Our reference: DOC19/871107-5
Date: 31/01/2020

**Proposed Snowy 2.0 - Segment Factory, Cooma – SSI-10034
Comments on response to submissions**

Thank you for providing the NSW Environment Protection Authority (EPA) with the opportunity to provide comment on the Response to Submissions (RTS) for the proposed Tunnelling Methodology (SSI-9208-MOD 2) received on 23 December 2019.

Attachment 1 Comments from Response to Submissions

Figure 4 | Sensitive Receivers (Orange dots R1 to R20)

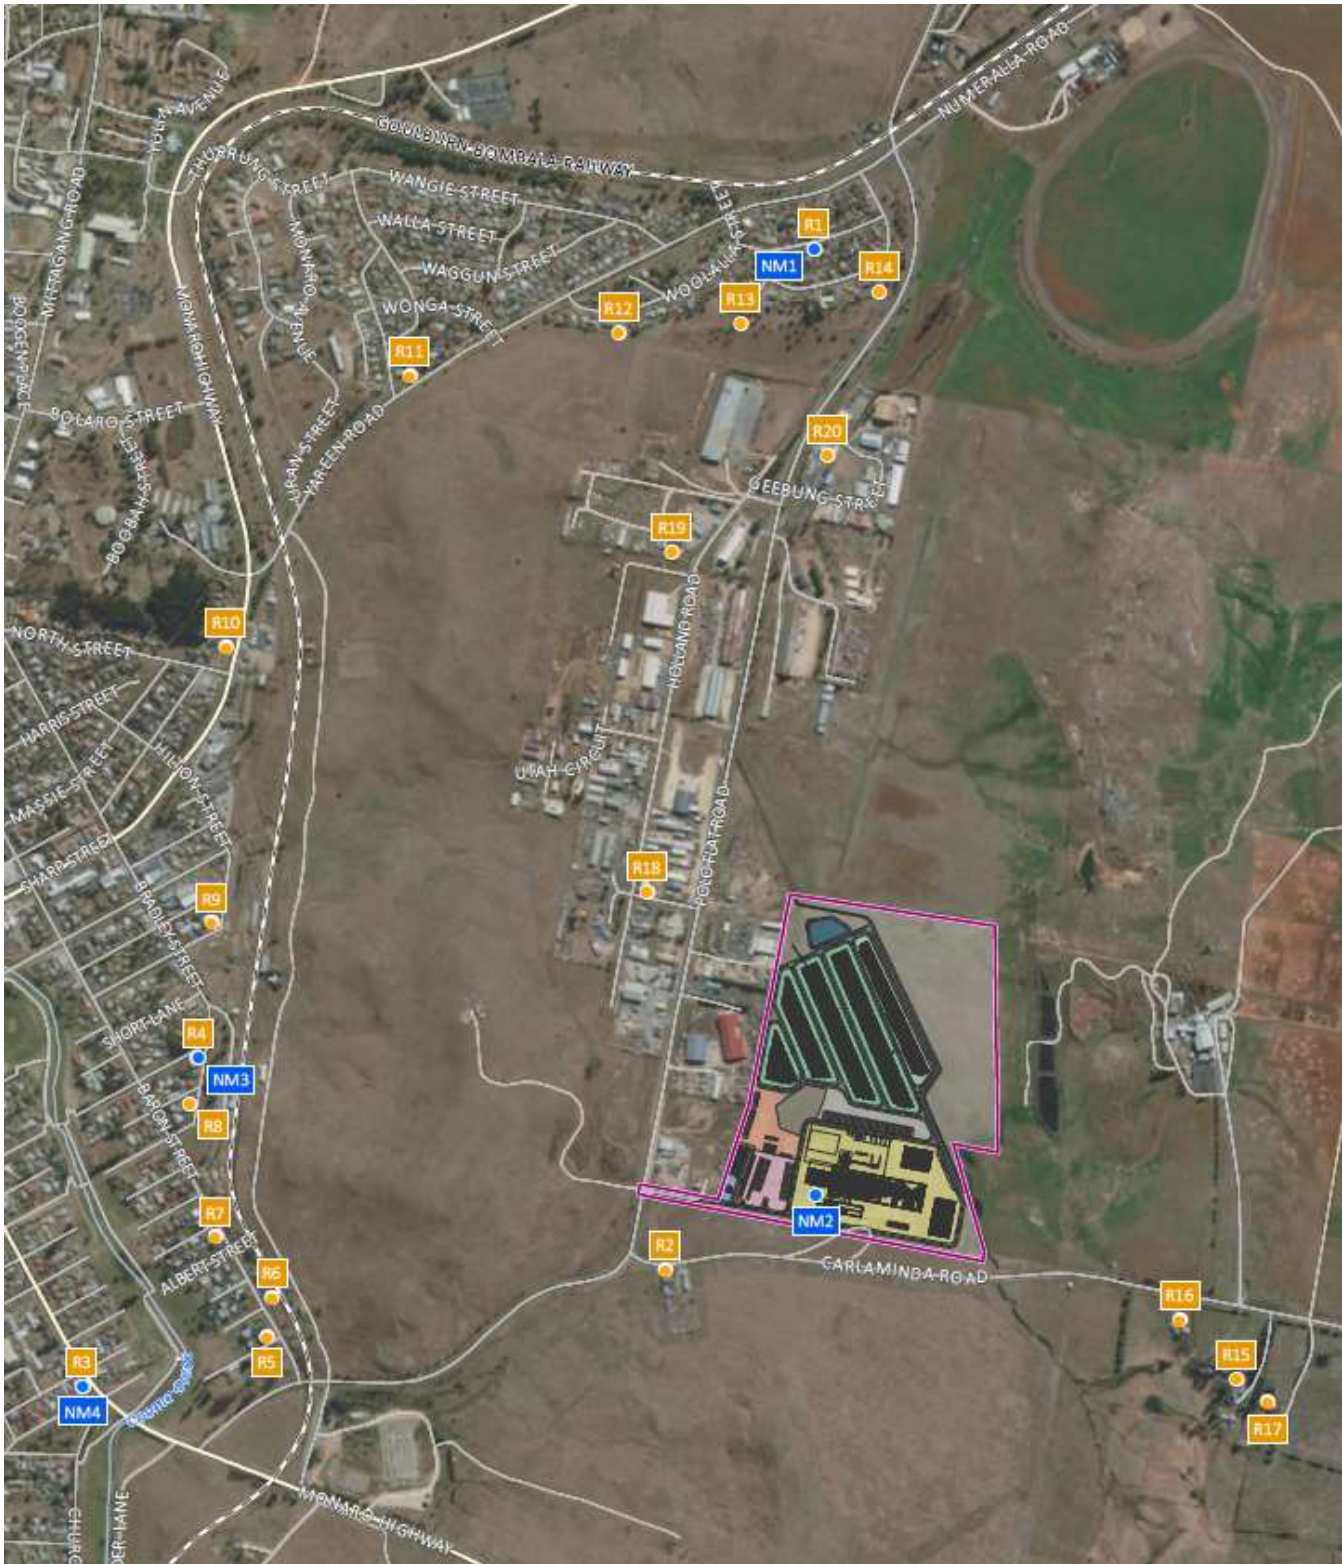
- a) the justification regarding the land-use zoning at the sensitive noise receivers (R2, R18, R19 and R20) and appropriate assessment criteria is satisfactory;
- b) the proponent has committed to regularly consult with all noise impacted residences and manage any concerns;
- c) the proponent has committed to prepare a management plan to manage traffic noise impacts;

**Figure 7.7** Cumulative 24-hour average PM<sub>2.5</sub> concentrations – industrial receptor R18

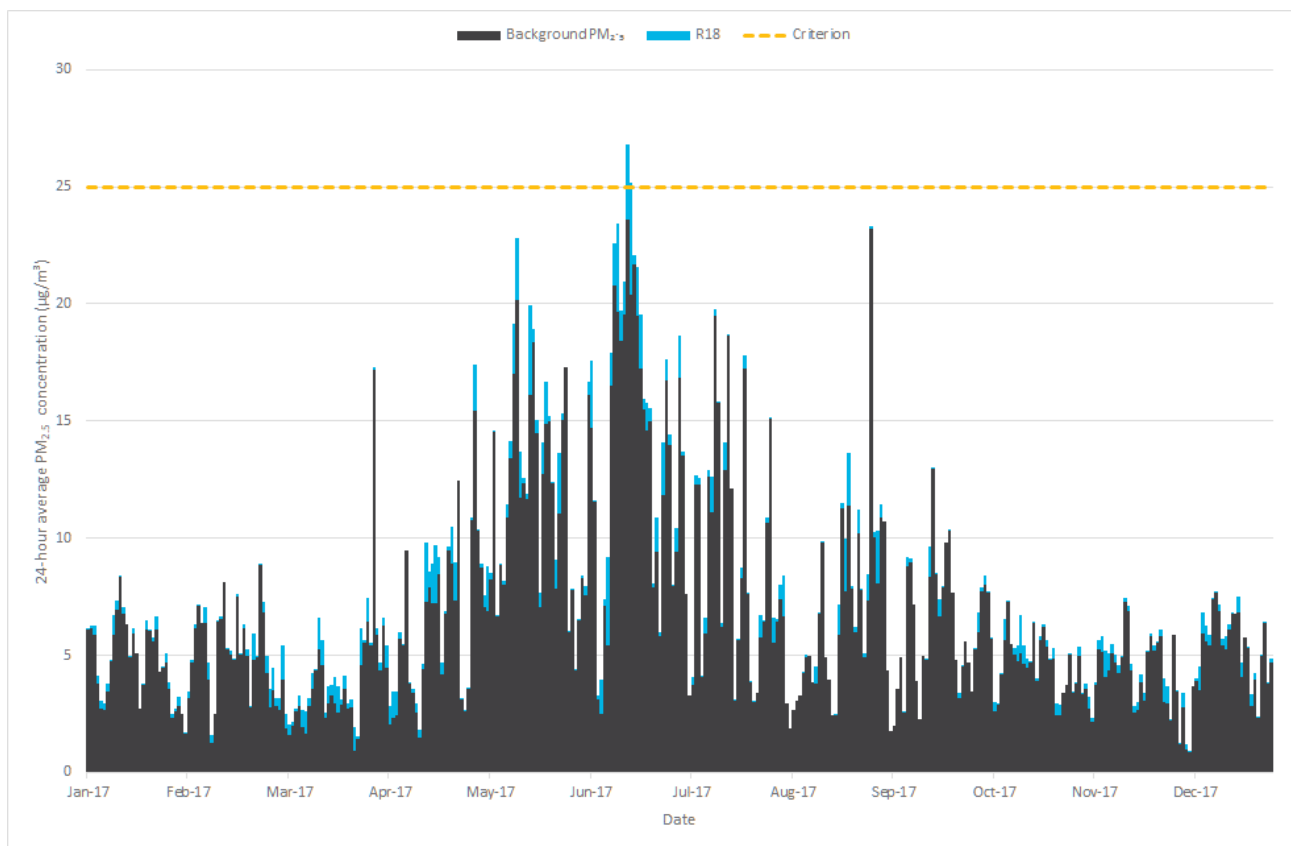
- d) based on the information provided in the Air Quality Impact Assessment (AQIA; emission inventory, background levels and adopted assumptions), an approximate 10% reduction in traffic emissions is still insufficient to avoid the majority of the predicted 24-hour PM_{2.5} exceedances at the sensitive receivers near the project boundary;

- e) while the sensitive receivers are located within industrial-zoned land, the *Approved Methods for the Modelling and Assessment of Air Pollutants in NSW* (Approved Methods) defines a sensitive receiver as a location where people are likely to work or reside. This definition does not vary according to the zoning of the land;

The EPA considers that the issue of additional exceedances of the PM_{2.5} 24-hour average impact assessment criterion can be addressed through a consent condition requiring the proponent to identify and implement all feasible and reasonable particulate mitigation measures.
